Our ref: DOC21/238759
Senders ref: SSD 10479

Subject: amended plans and documentation for the proposed 200 Aldington Road Industrial Estate (SSD-10479) in response to issues raised with the Applicant's Response to Submissions

Attachment A – EES comments on Response to Submissions for 200 Aldington Road Industrial Estate (SSD-10479)

KEYPLAN

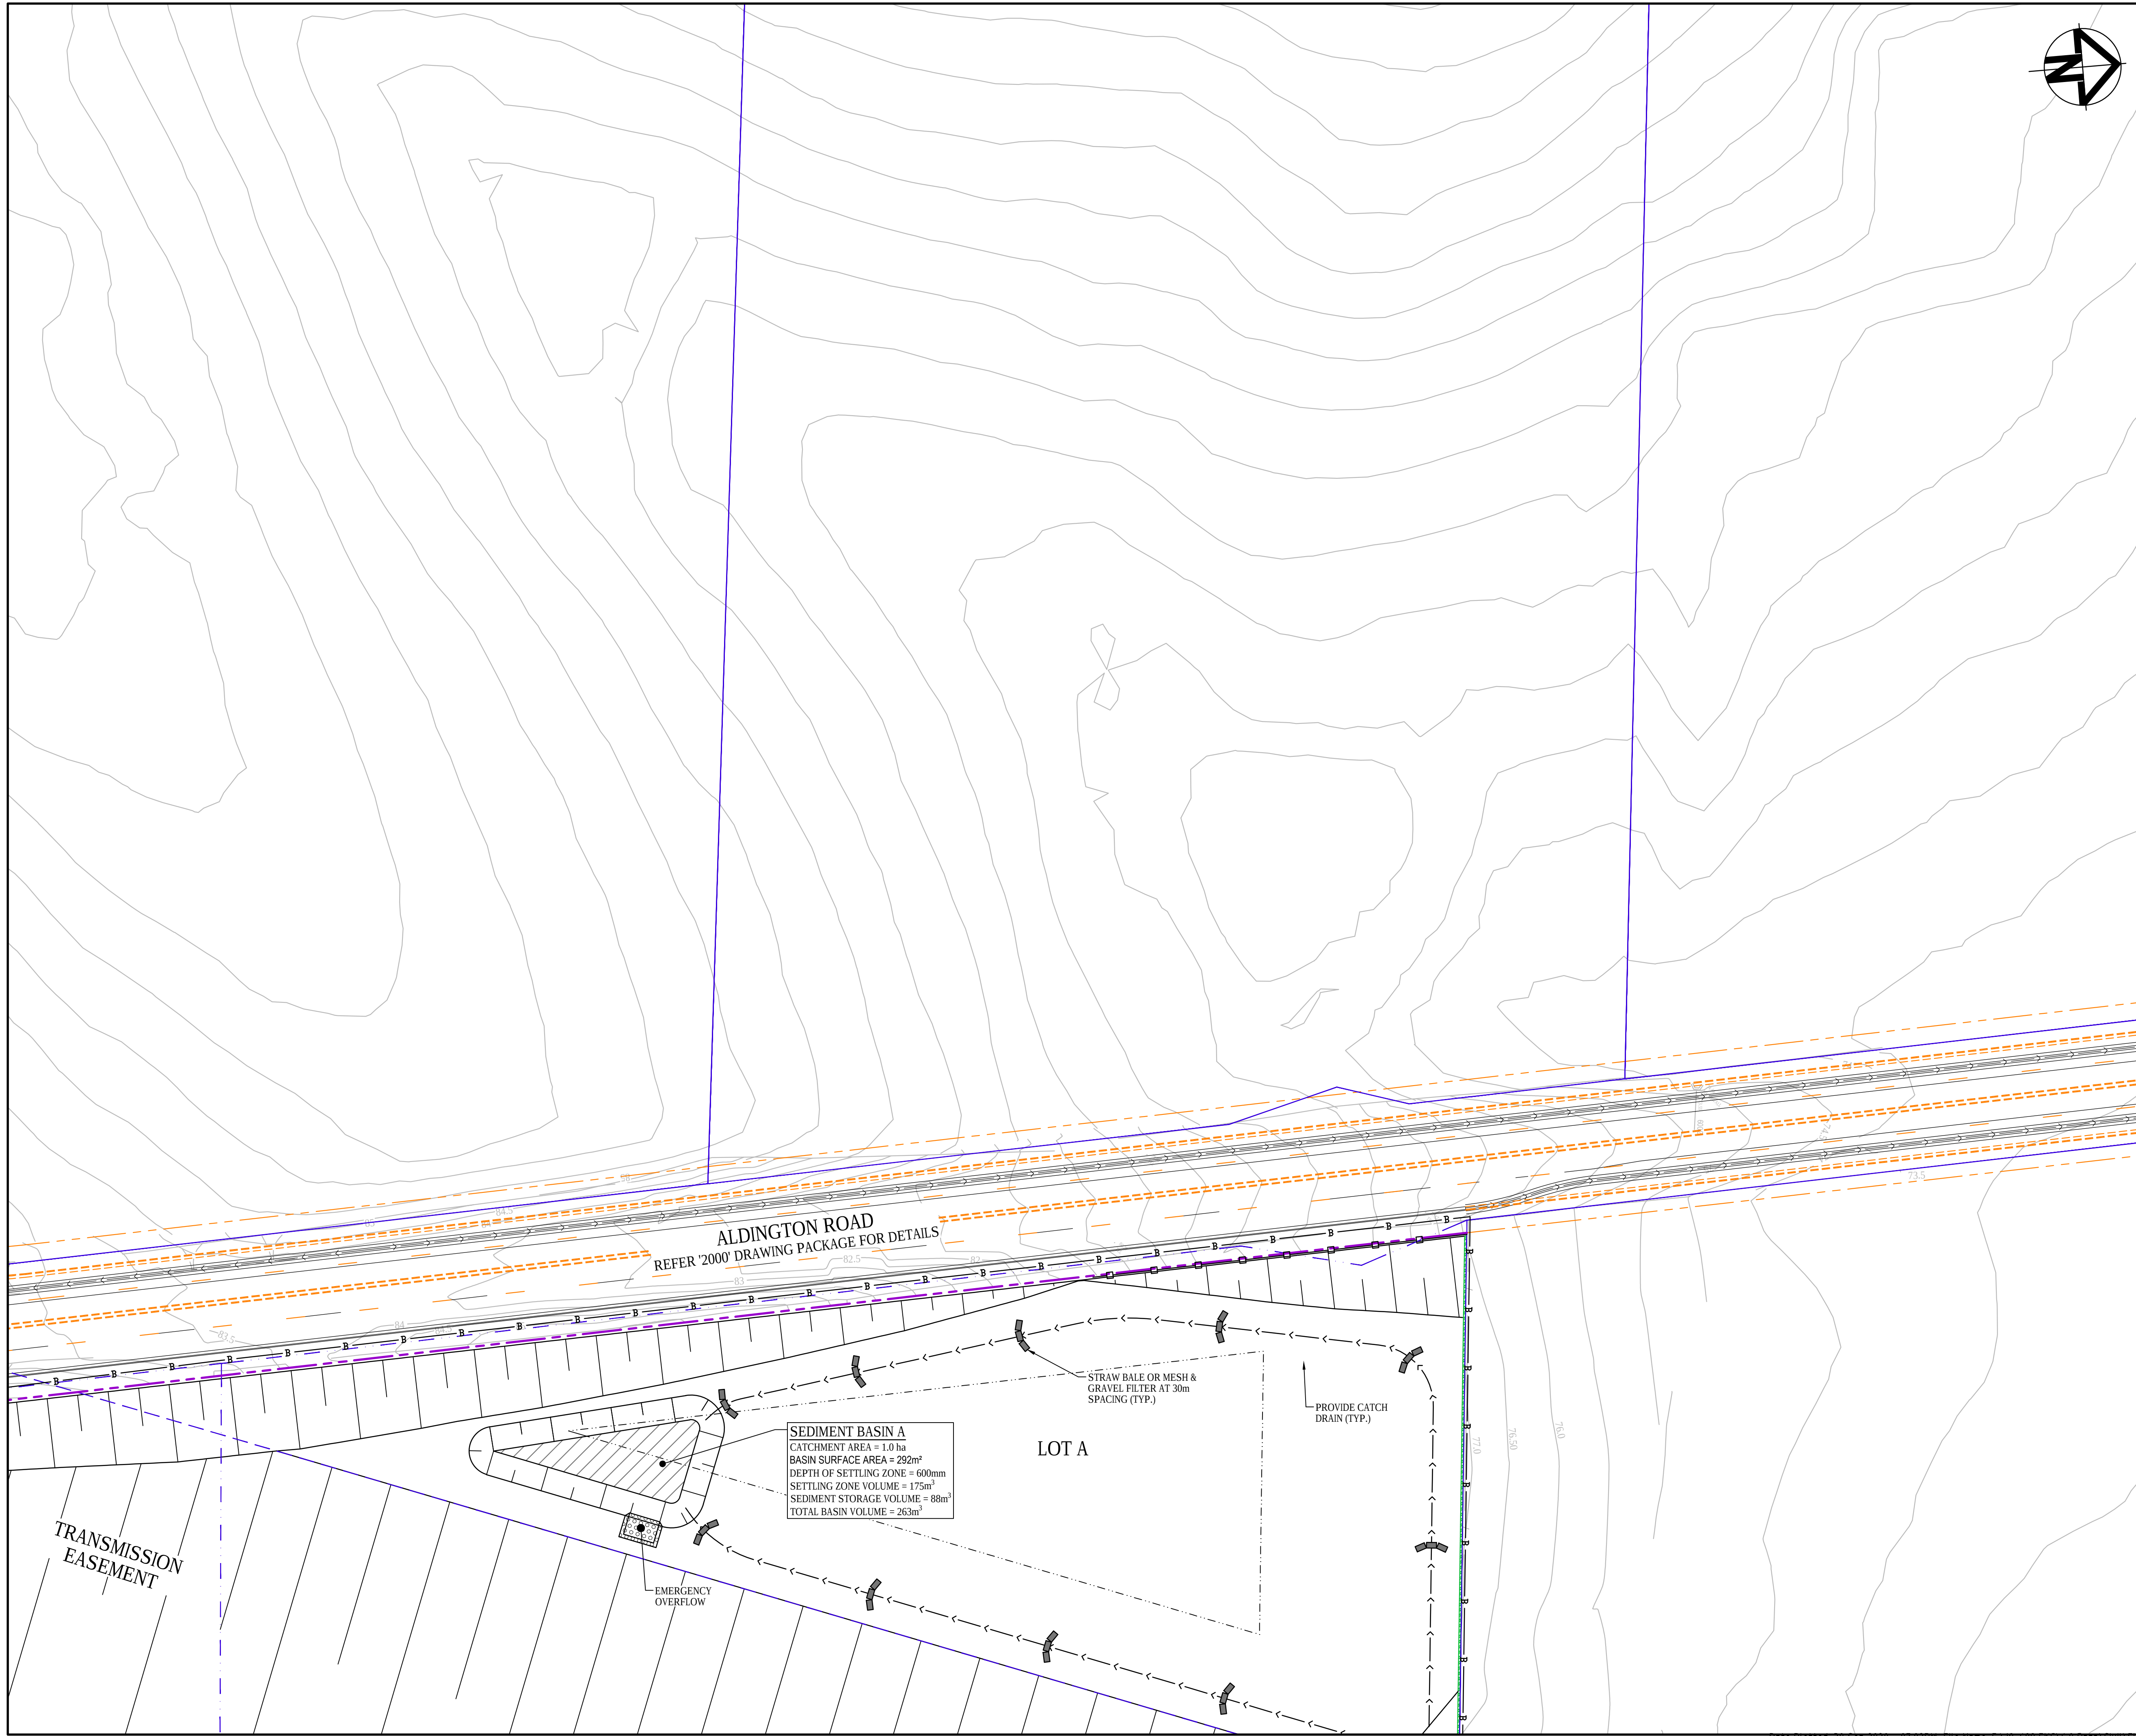
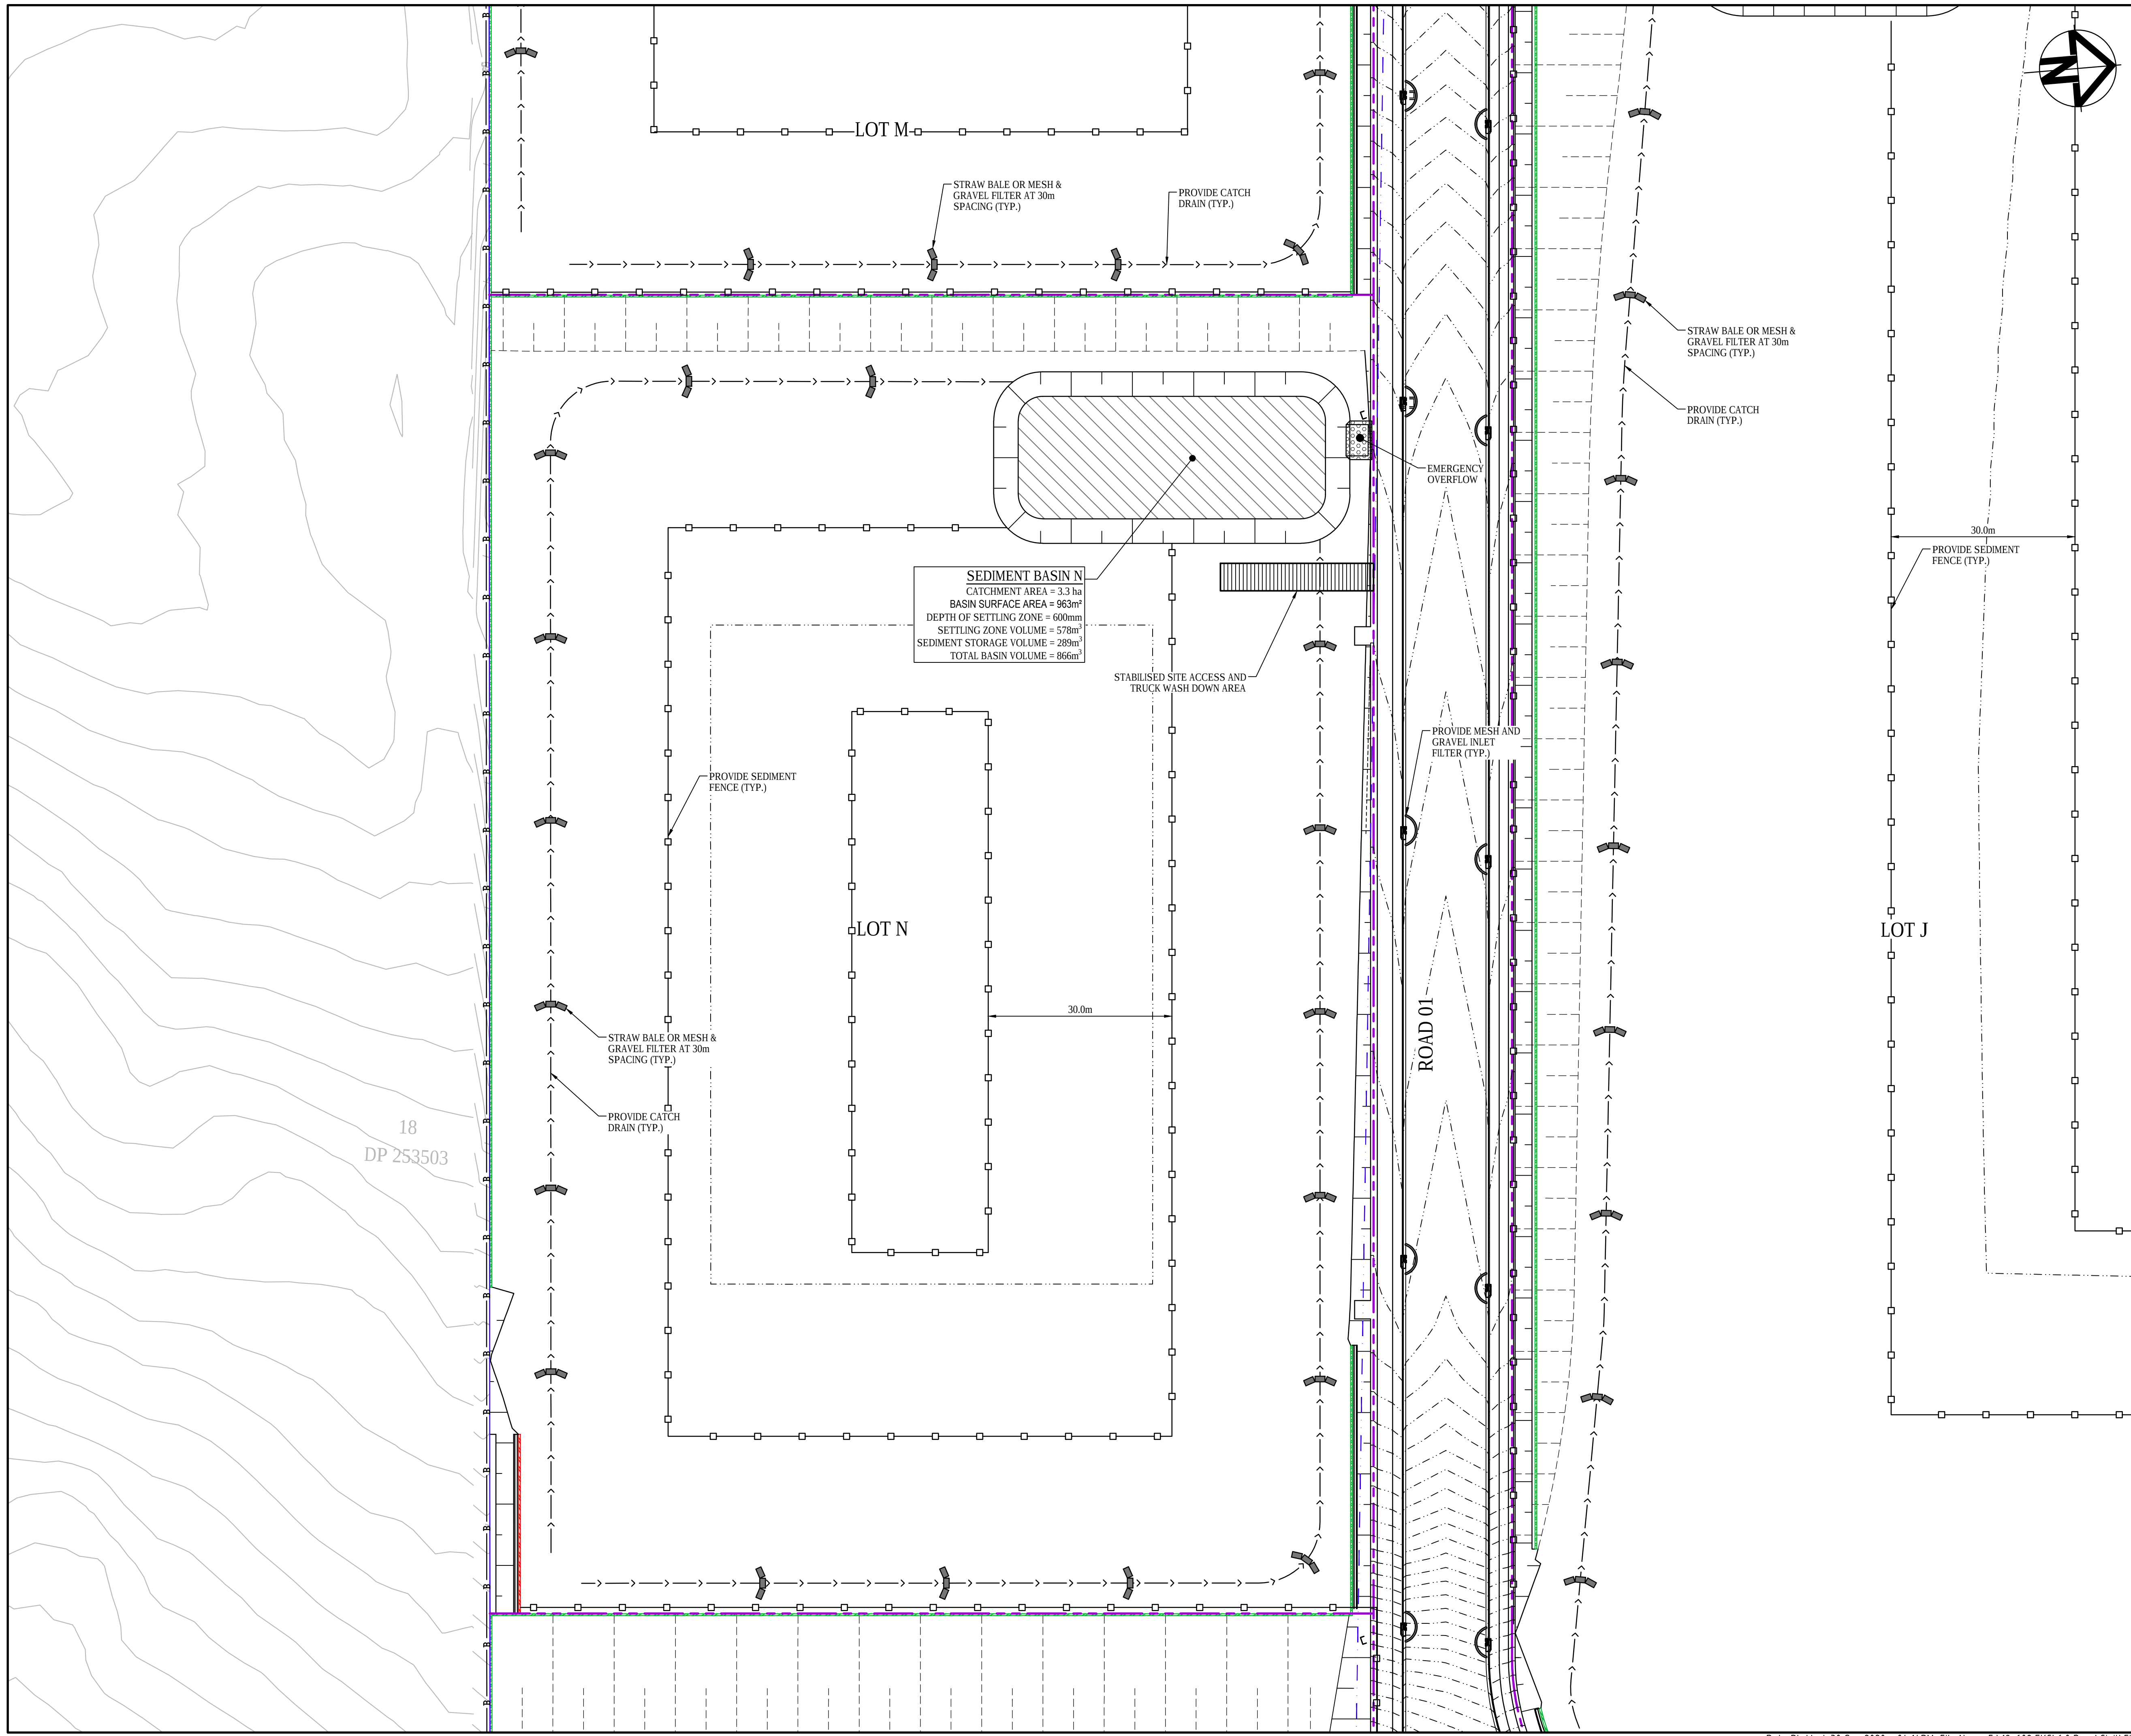
Section 8 – Sedimentation and Erosion Control

Sedimentation and erosion controls should demonstrate that EES's Construction Phase Targets are being achieved. Please refer to Table 1 of the EES 'MUSIC MODELLING TOOLKIT – WIANAMATTA' previously provided to DPIE Planning and Assessments Group on 5 August 2021.
